**Town and Country Planning Act 1990
Application for Permission to Develop Land**

Response from Pollution & Noise Control

PNC Reference No:	WK/201800284
Name of Planning Officer dealing with the matter:	Neil Bearcroft
Application Number:	2017/94373
Proposed Development:	Demolition of former public house and change of use of land to car sales forecourt.
Location:	Rickys Bar, 311 Leeds Road, Huddersfield, HD1 6NZ
Date Required By Planning:	25/01/2018

DRAWING TITLE:
 PROPOSED SITE PLAN

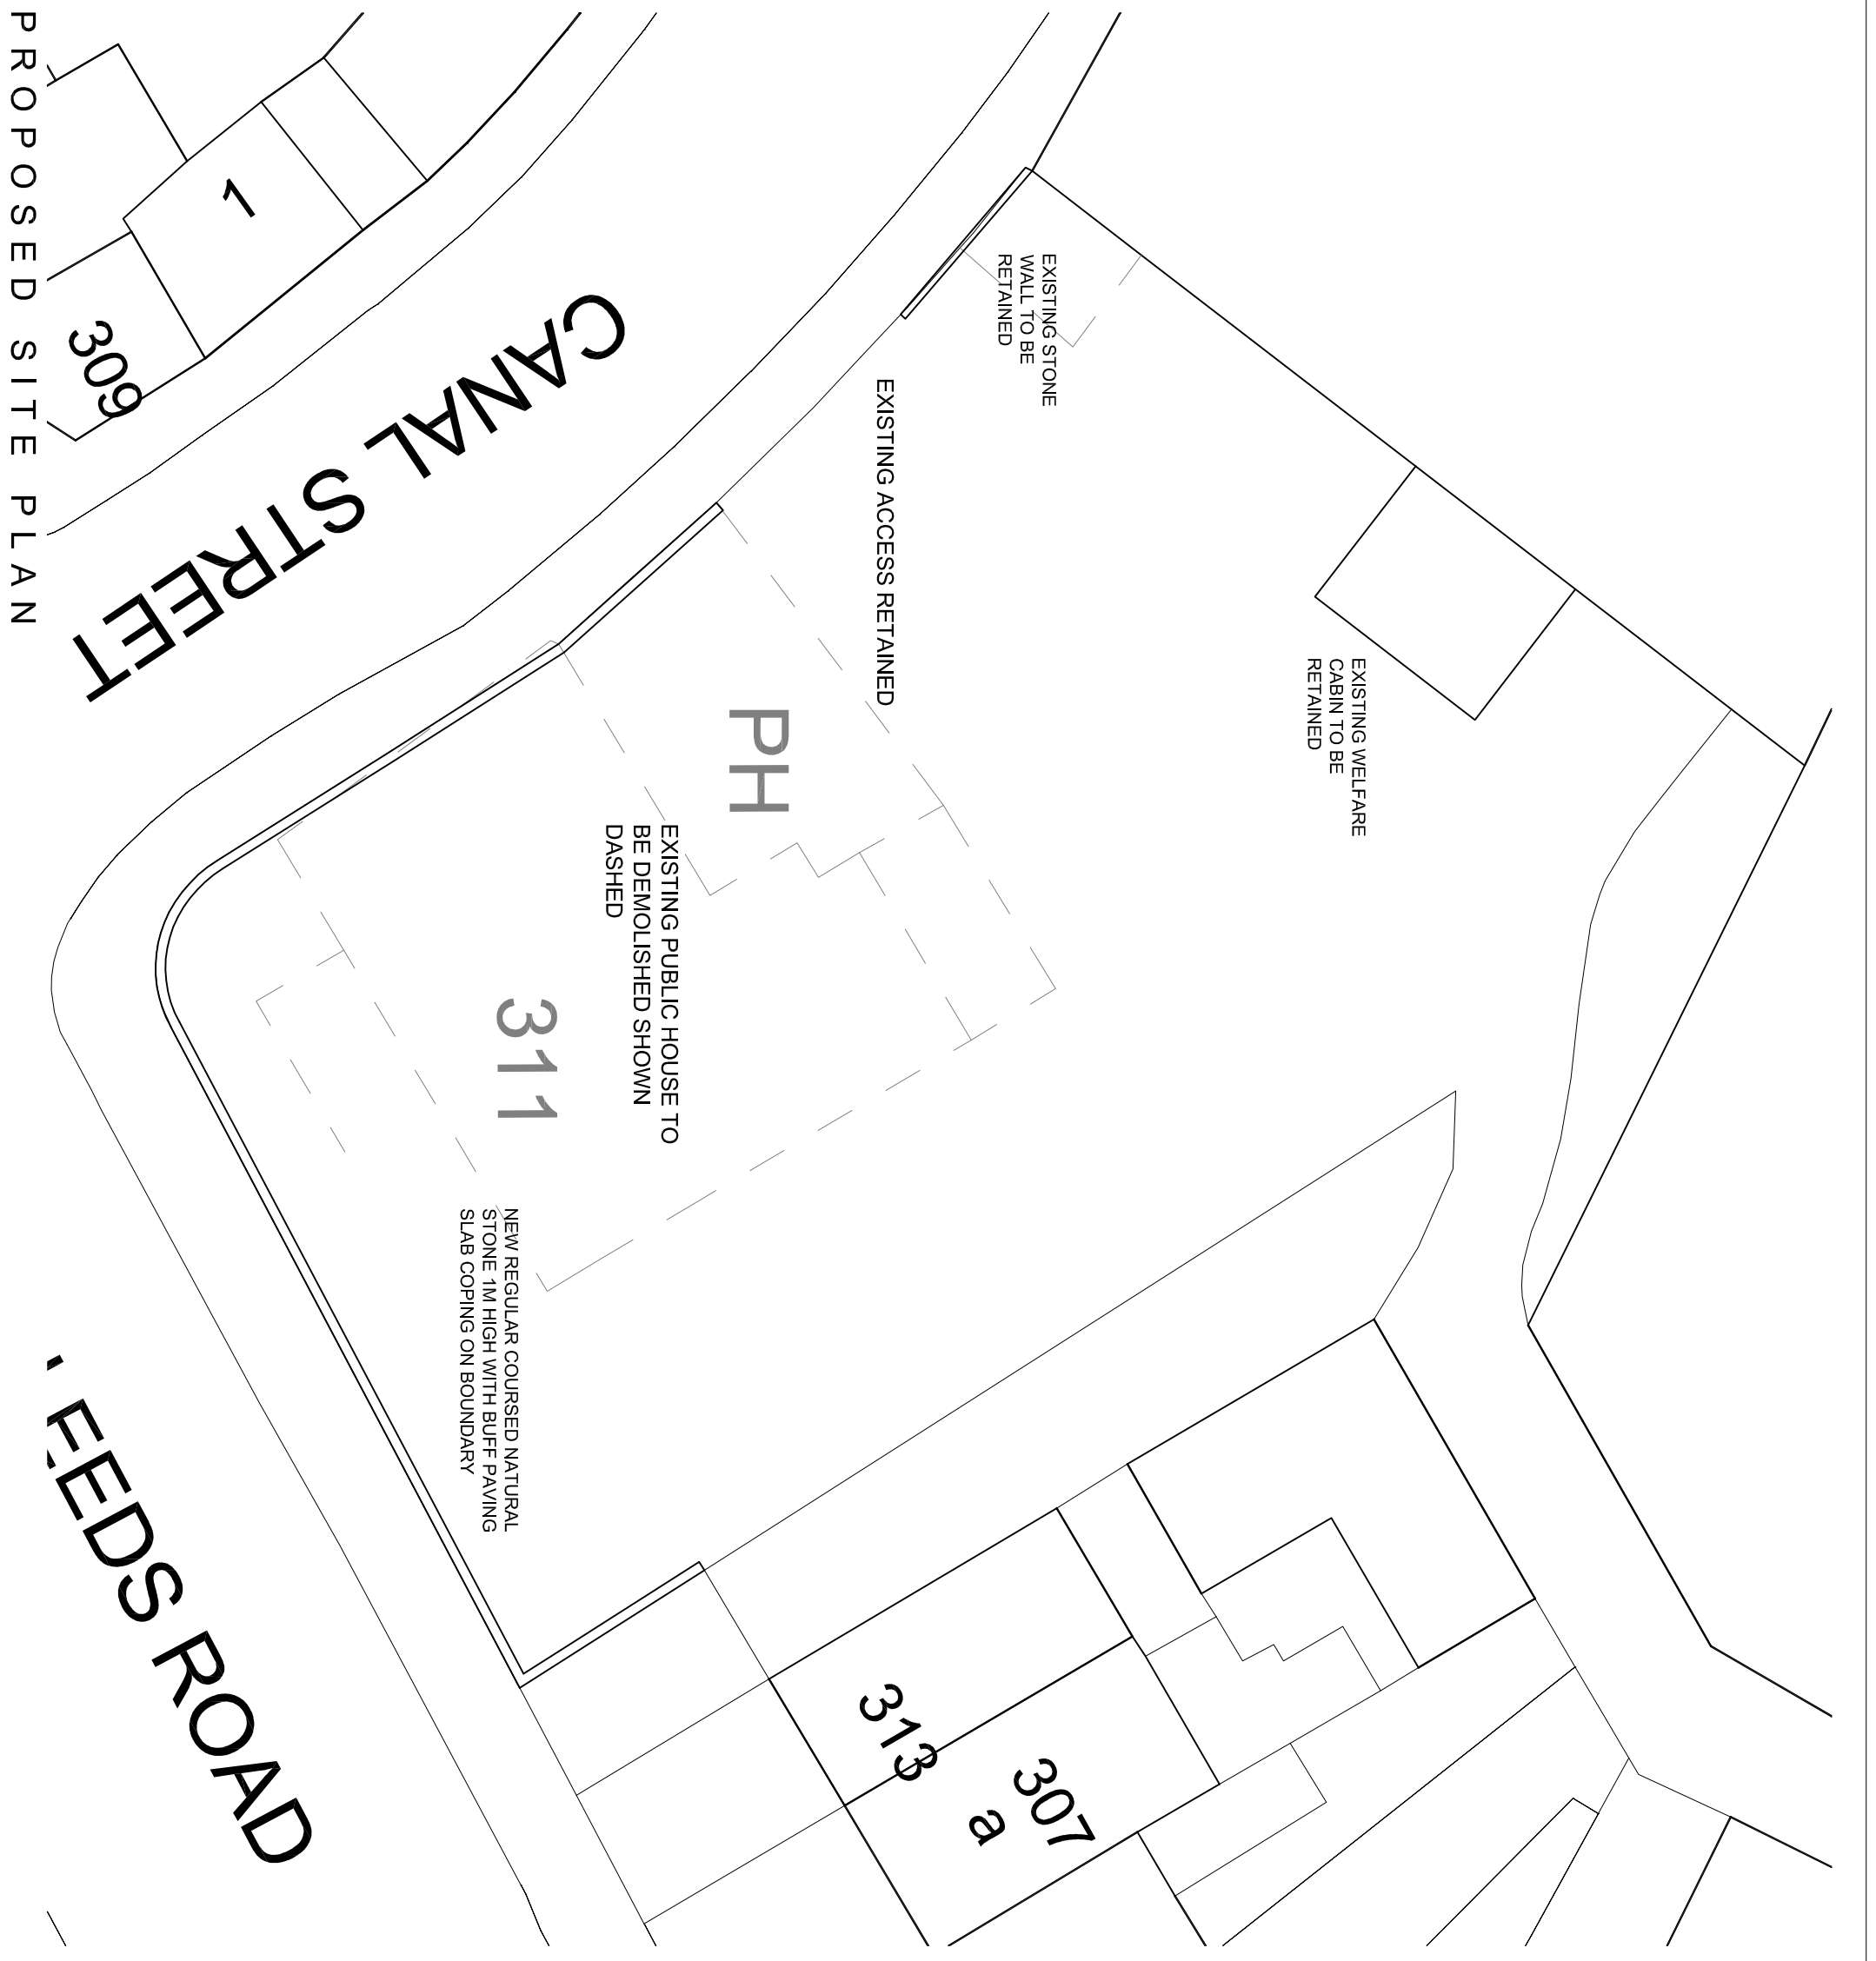
COMMENTS			
<p>Pollution and Noise Control have no objection to this application provided that there are reasonable hours of use. No hours of operation have been specified in the application information. These comments are made with the understanding that there are going to be no floodlights at the site. If lighting is proposed, Pollution and Noise Control request further consultation.</p>			
Date:	15 th January 2018	Officer:	Lisa Shaw 01484 221000
